**Application No:** 19/01177/F

**Proposal:** Erection of 10 no. two-storey residential dwellings with access off South Side, including a new pedestrian footway, parking and garaging, landscaping, and all enabling and ancillary works

**Location:** Land To The South And Adj To South Side Steeple Aston  
**Parish:** Steeple Aston

Title : Proposed Pedestrian Facilities with Shared Space

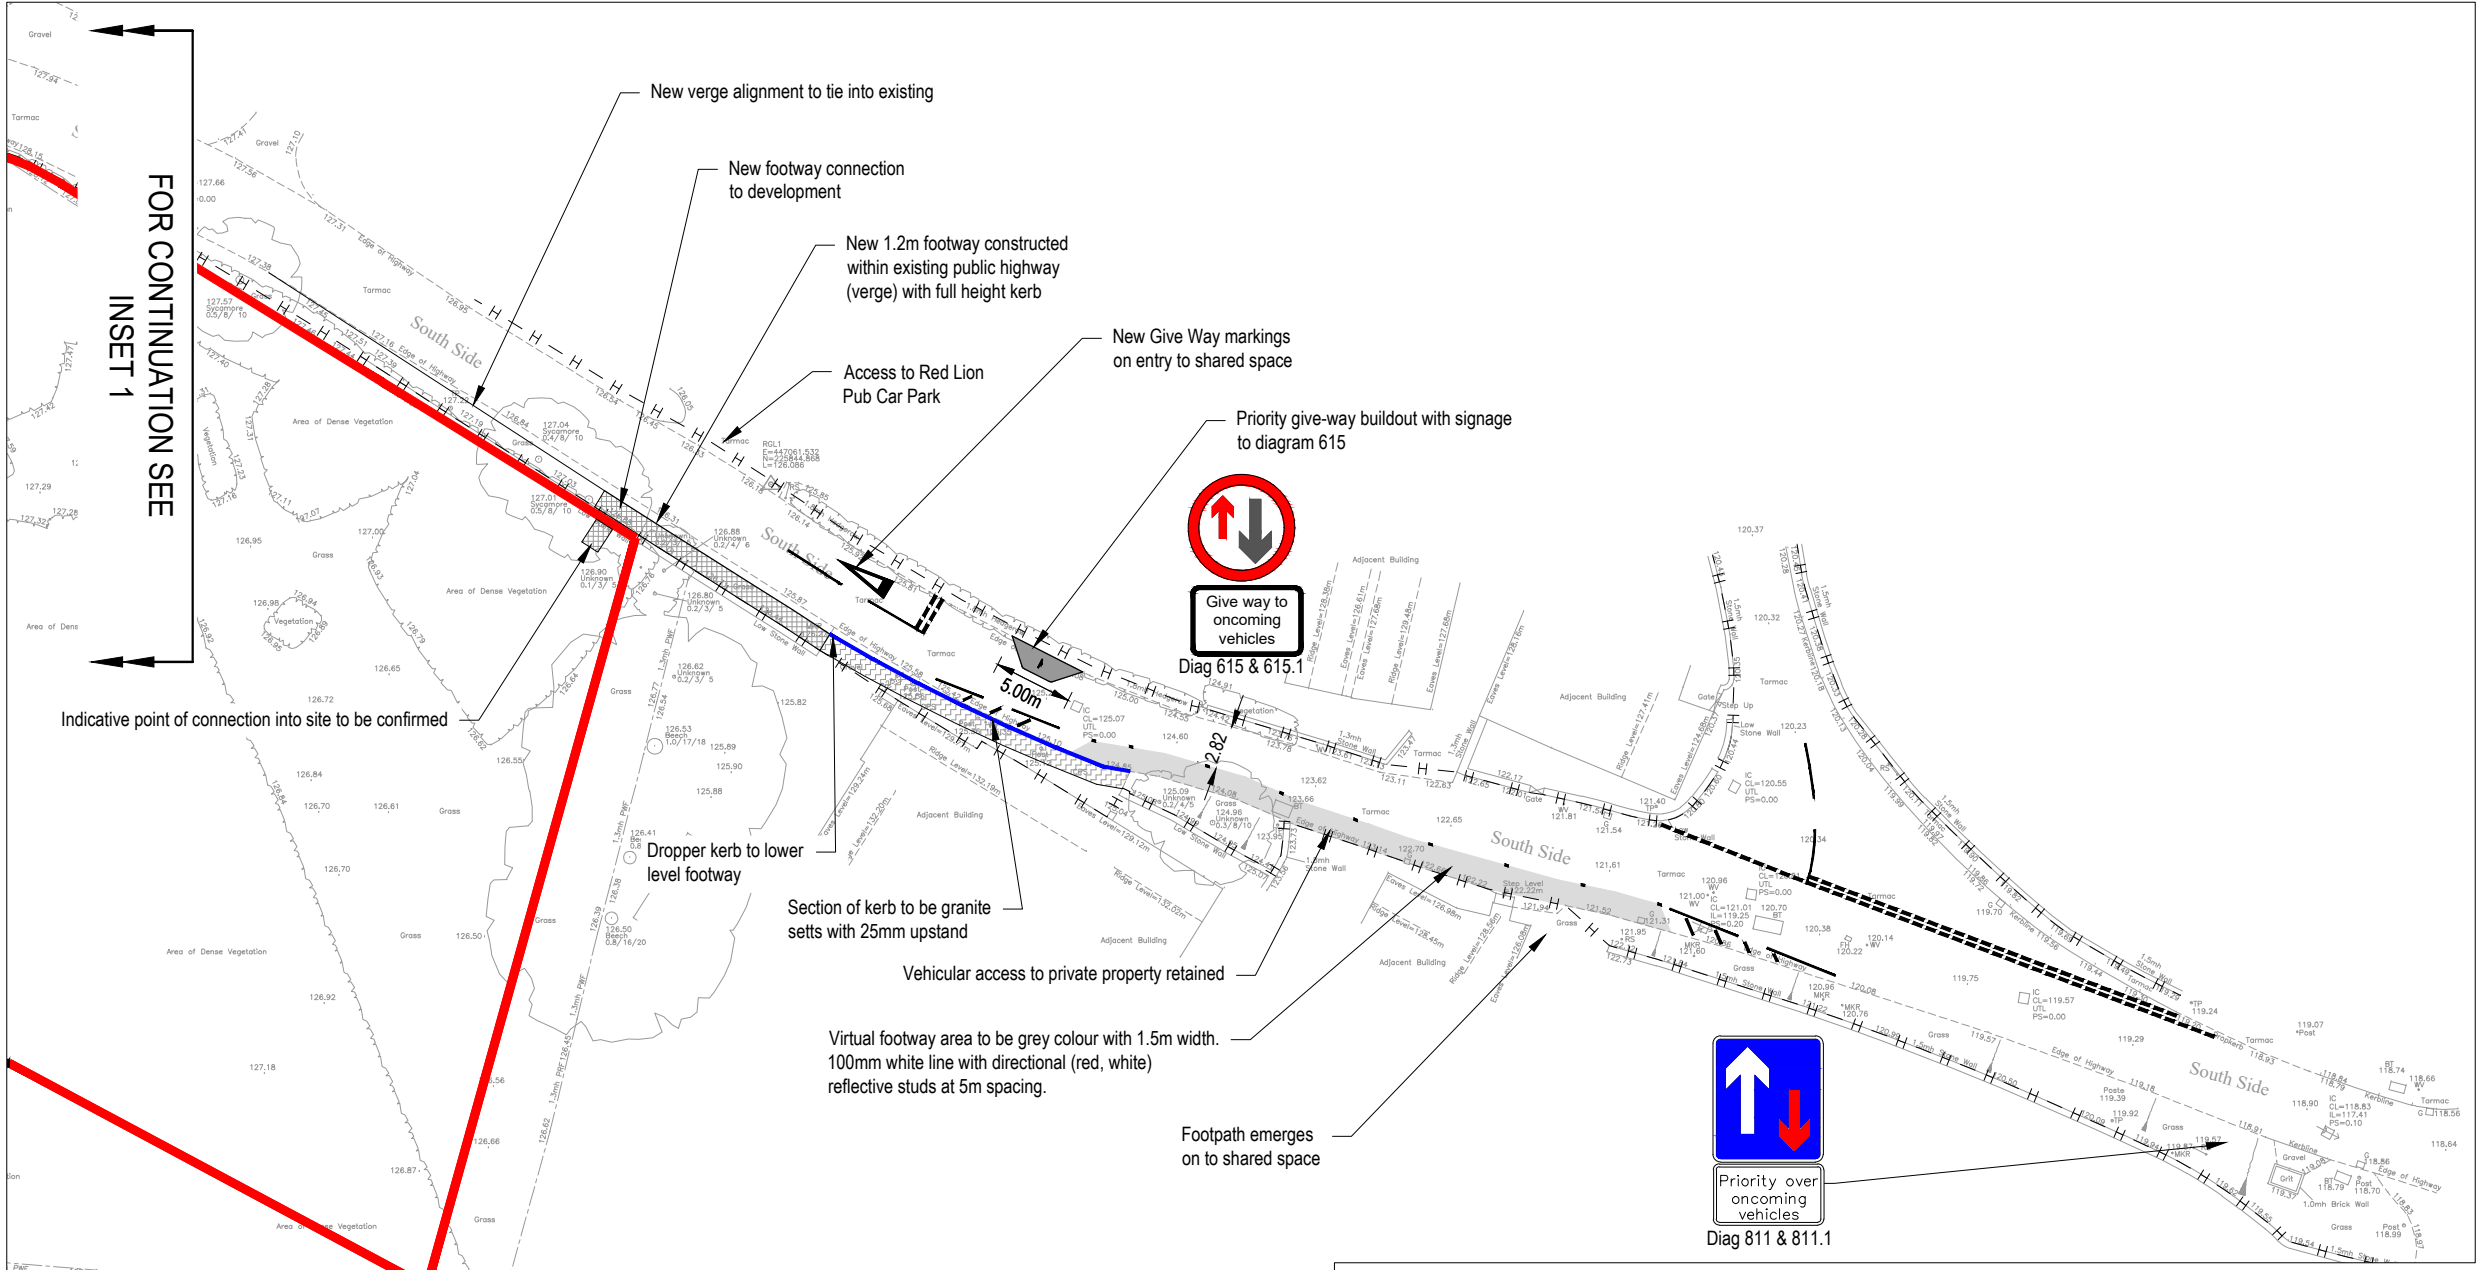
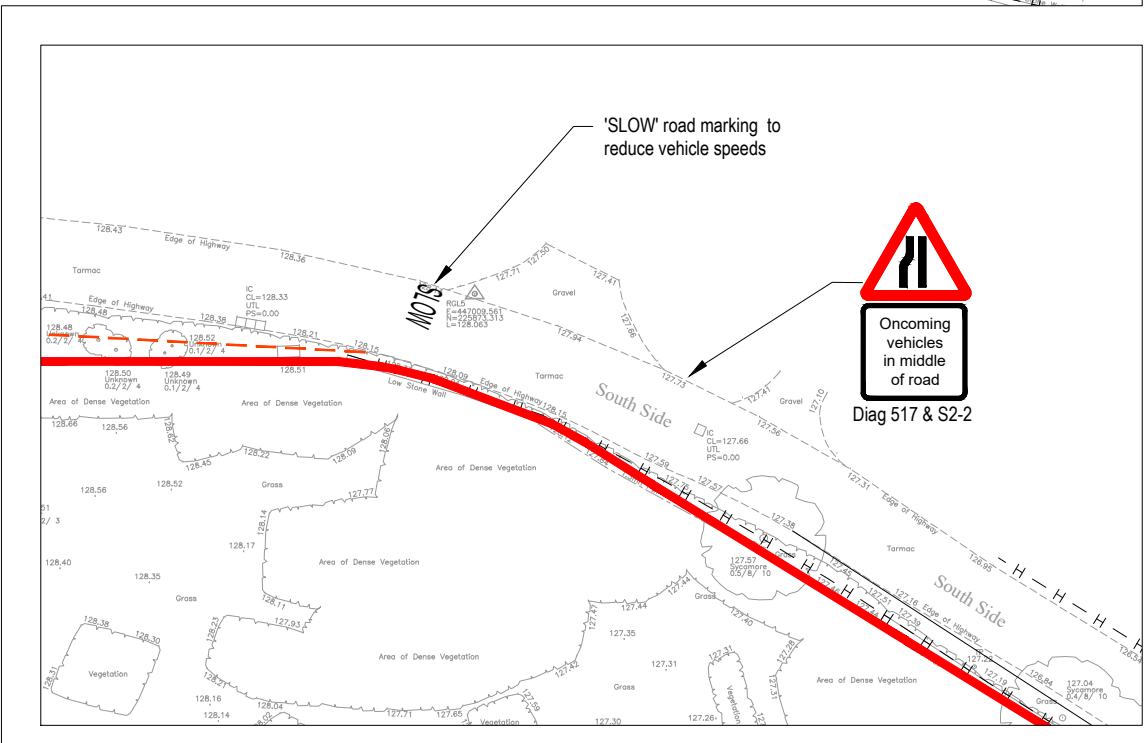
- The new road and footpath layout (if approved by OCC Highways) will provide improved pedestrian access not only for the site itself, but also for the twelve or so existing dwellings on the other side of the road; and down Sixtyfoot towards Hopcrofts Holt.

- Road markings and signage: can we have some assurance that the new road markings and signage will be well maintained so that the new road layout preserves a high degree of safety?

- The narrowness of the road where there is to be a 'build out': we have been approached by a local farmer who has pointed out that he needs to be able to get wide farm vehicles into and through the village. Can he be assured that this will be possible?
